Householder Application for Planning Permission for works or extension to a dwelling.
Town and Country Planning Act 1990

Number	<input type="text" value="22"/>
Suffix	<input type="text"/>
Property name	<input type="text"/>
Address line 1	<input type="text" value="Middleton Drive"/>
Address line 2	<input type="text"/>
Address line 3	<input type="text"/>
Town/city	<input type="text" value="Eastcote"/>
Postcode	<input type="text" value="HA5 2PG"/>
Description of site location must be completed if postcode is not known:	
Easting (x)	<input type="text" value="510409"/>
Northing (y)	<input type="text" value="189613"/>
Description	<input type="text"/>

Single storey extension to sides & rear

Drawing Title		
Proposed Elevations		
Scale 1 : 50	Date 13/08/19	Drawn By SRW
Drg No. 388PL02-3

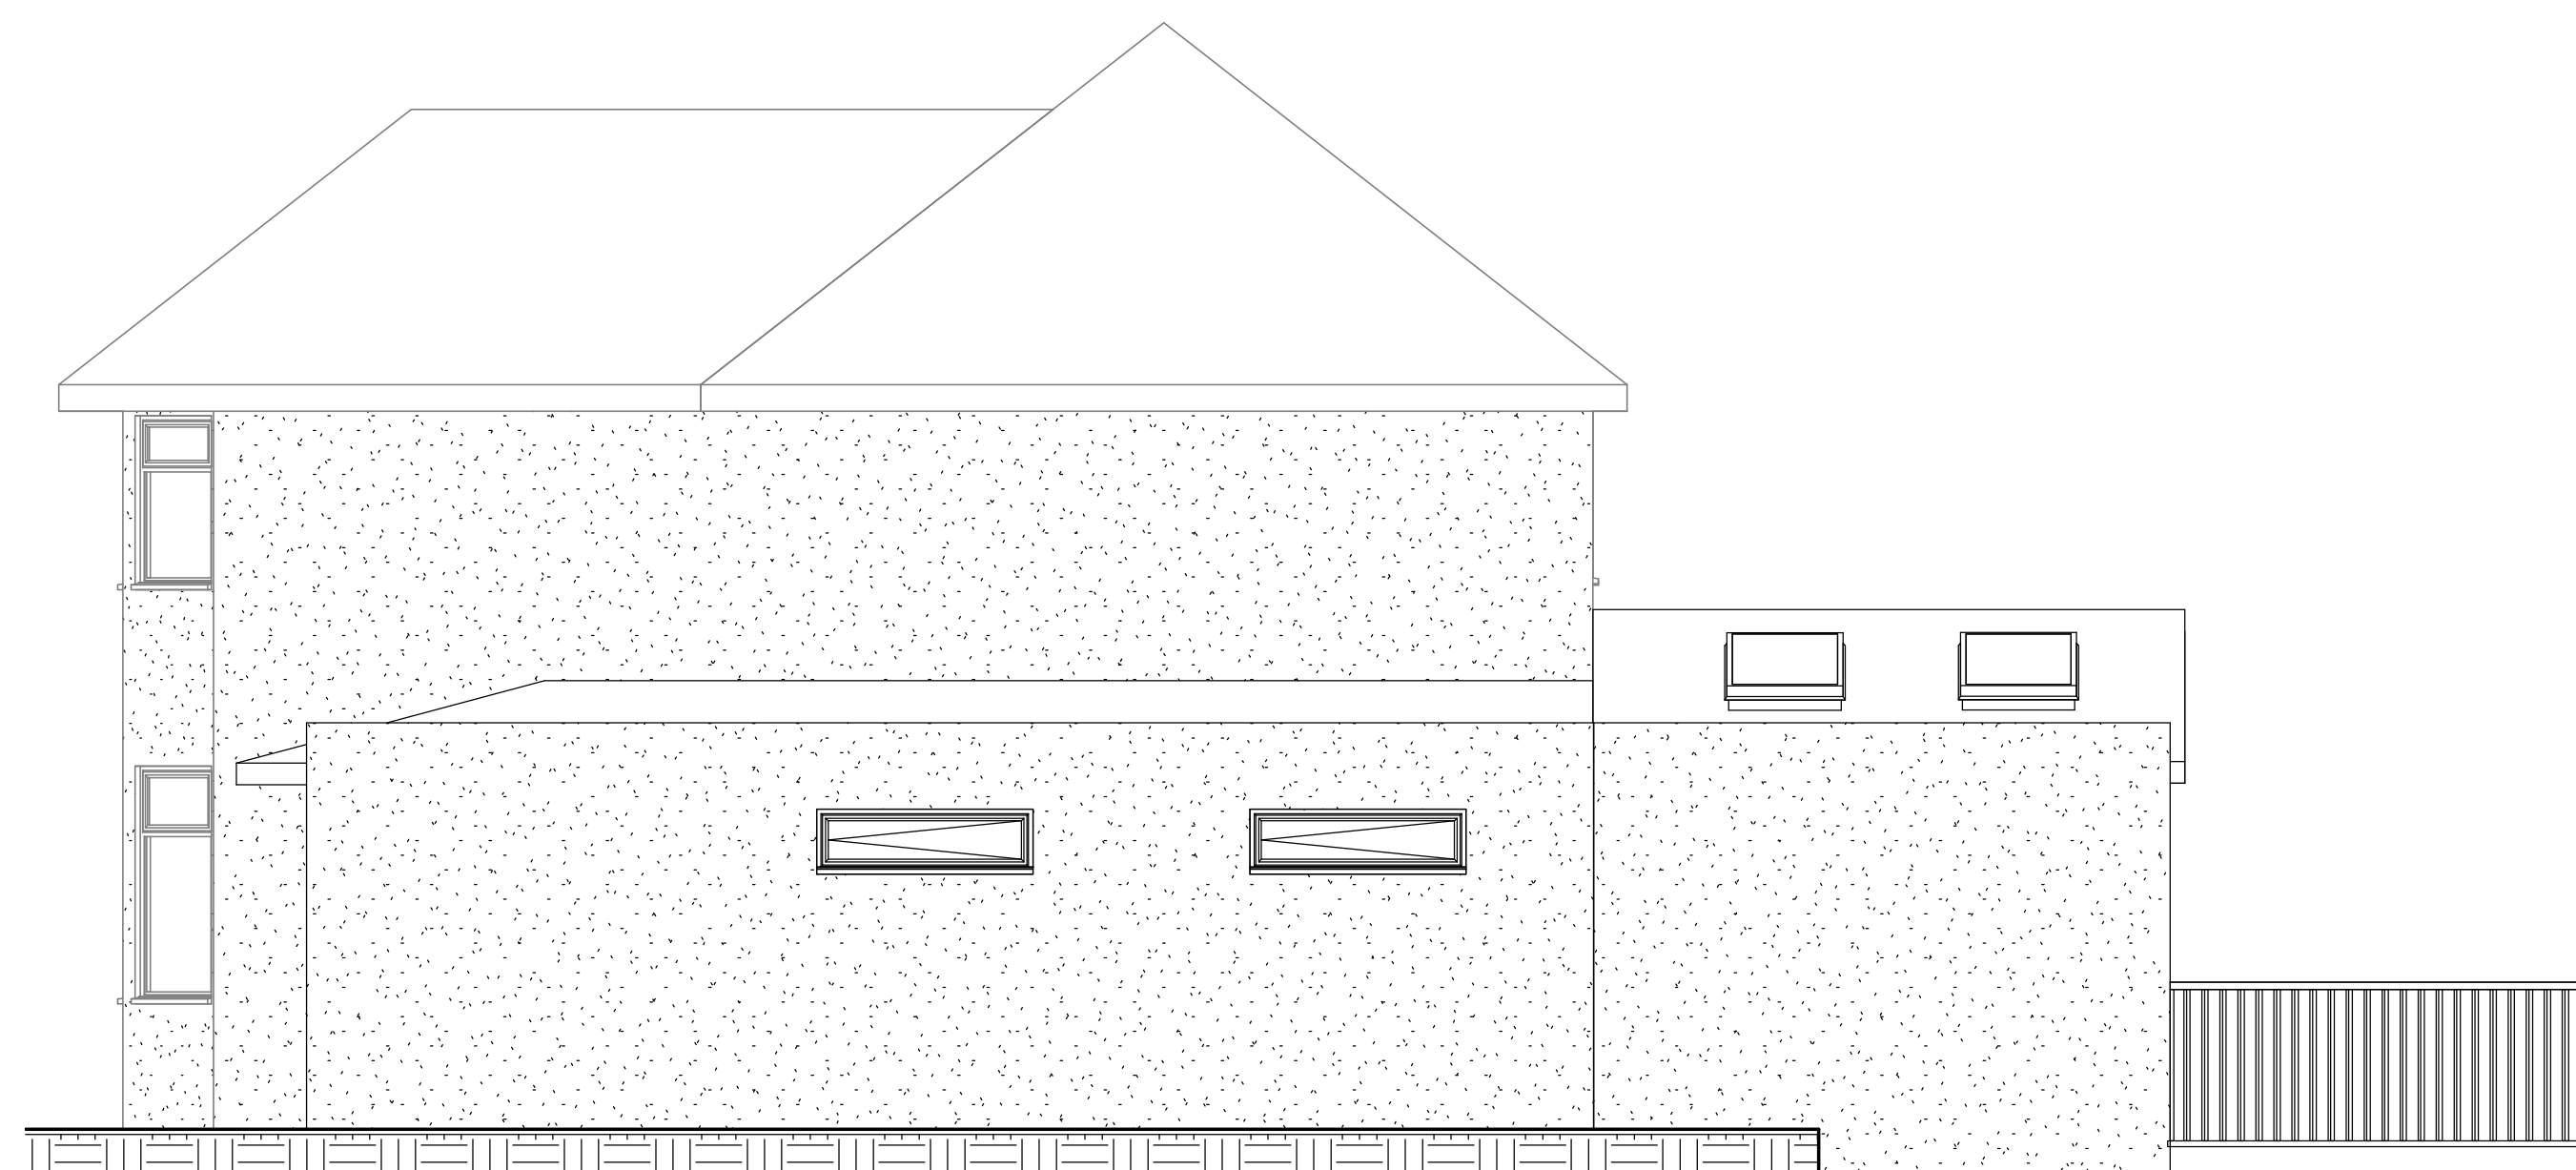
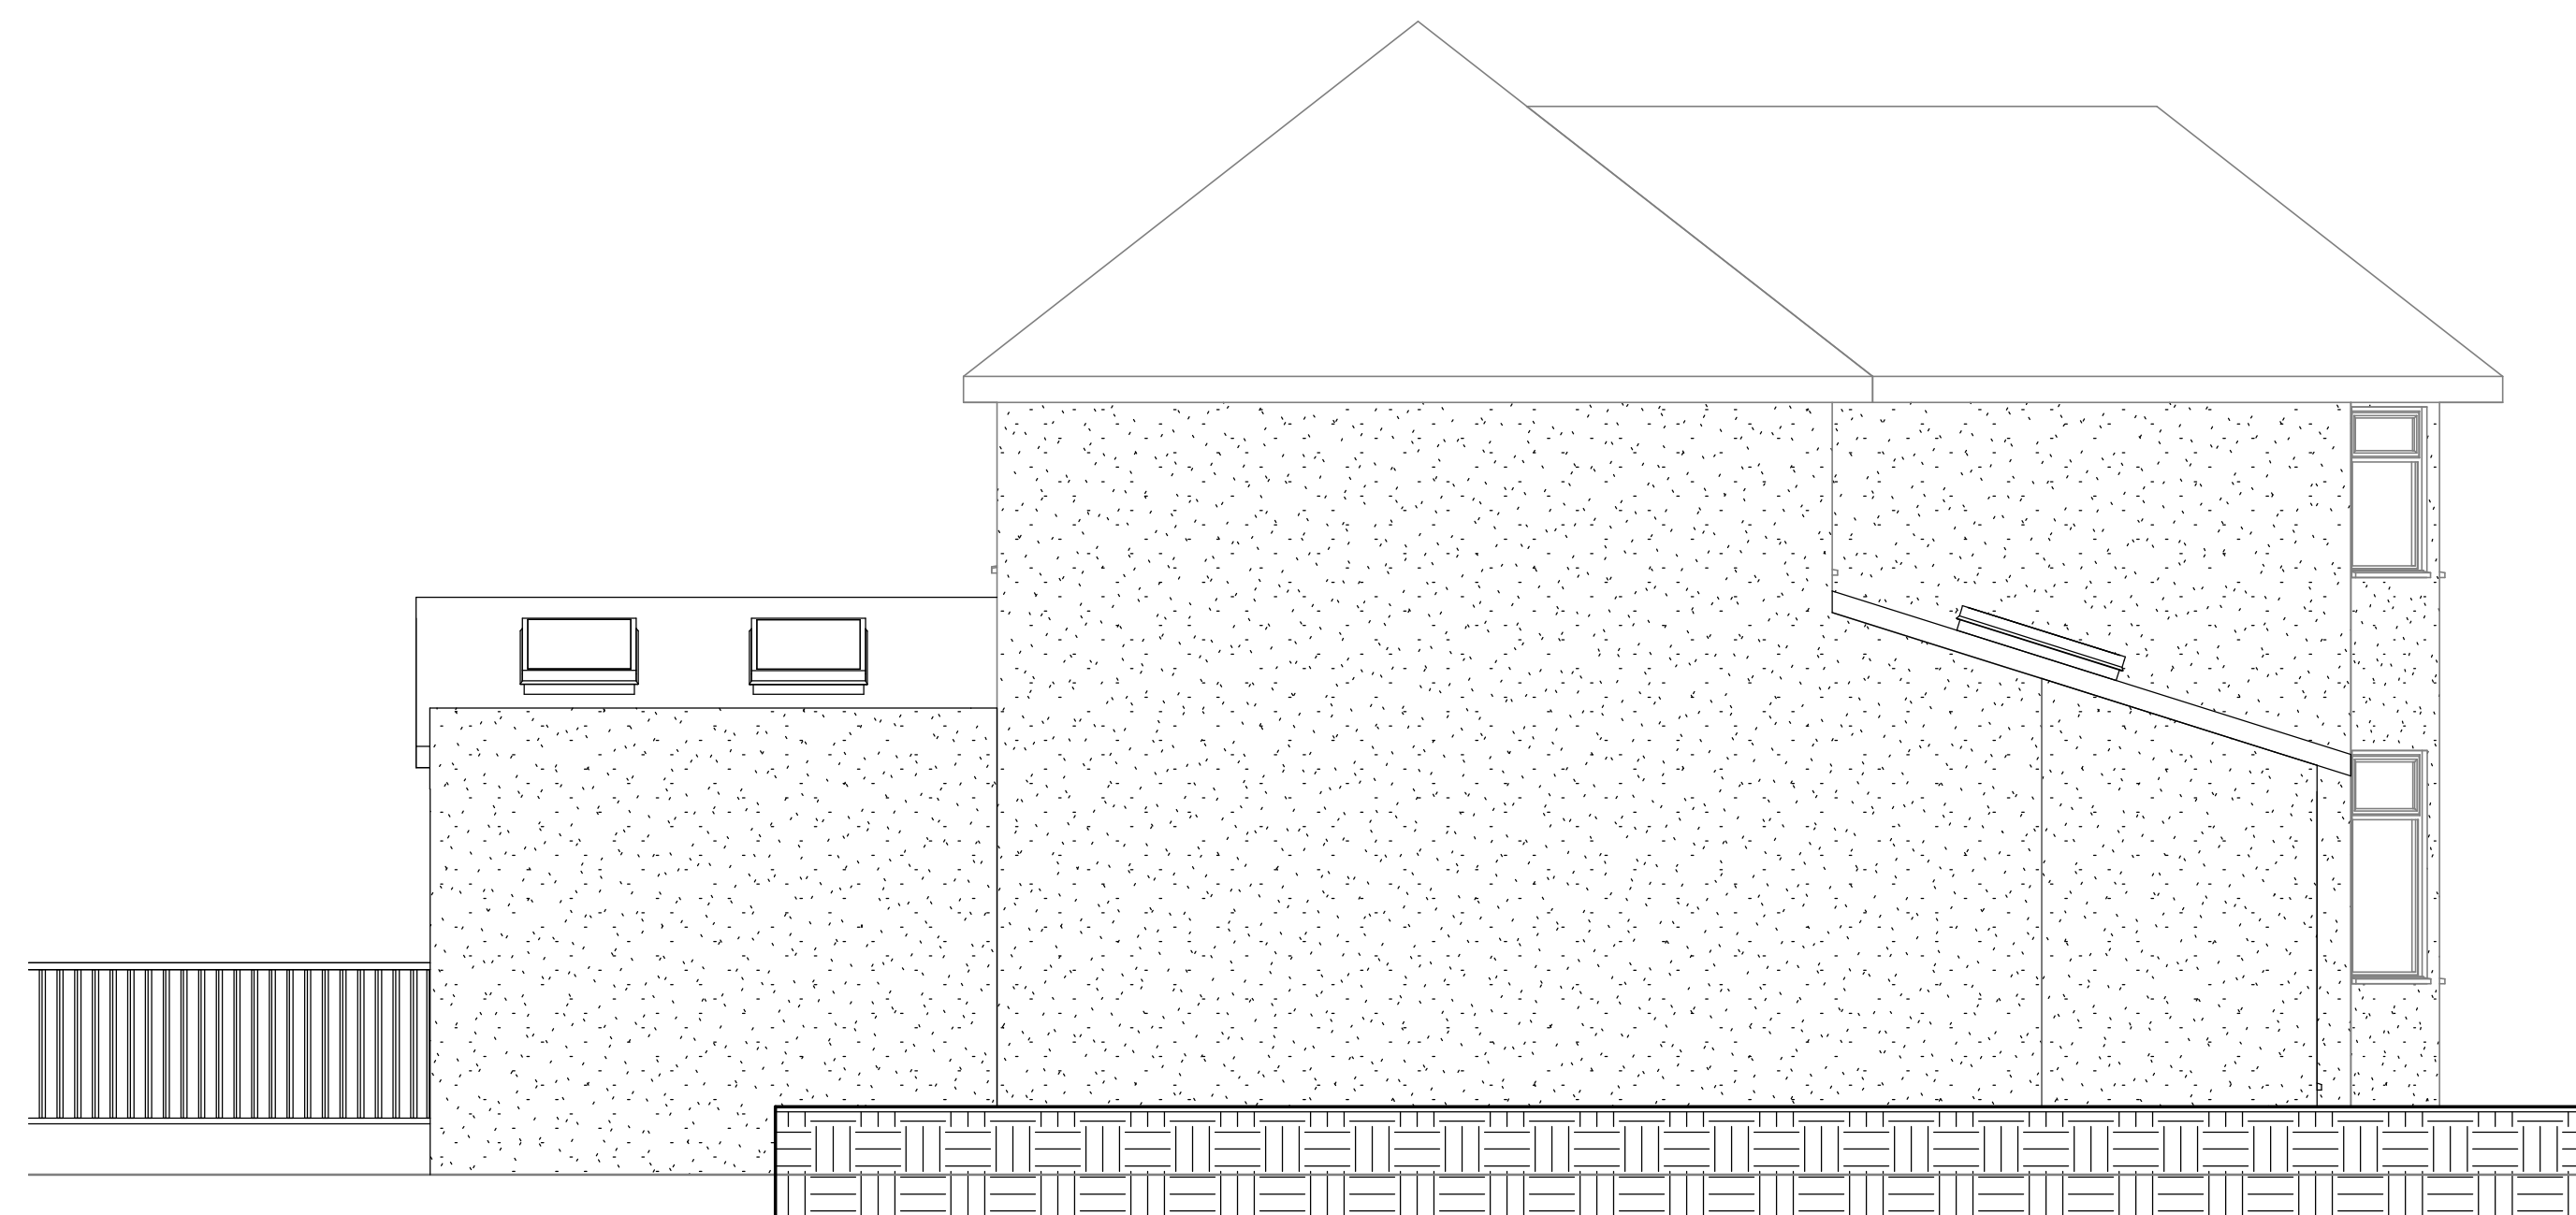
The pitched roof on the side extension must not exceed 3.4m in height. It may be possible for the greater height on the dual pitched rear extension due to the existence of the neighbour's at 20 Middleton Drive rear extensions having a similar height, at least that is how I would assess it.

The additional decking would appear not to extend beyond their existing extensions, if so, would not give rise to any additional overlooking or loss of privacy. It would be prudent to show the depth and height of the existing extensions at 20 Middleton Drive on your plans to give the comparison. Planning permission was granted in September 2016 for 20 Middleton Drive for a single storey side and rear extension and the installation of timber decking to the rear under reference 71940/APP/2016/2064 which you may want to look at.
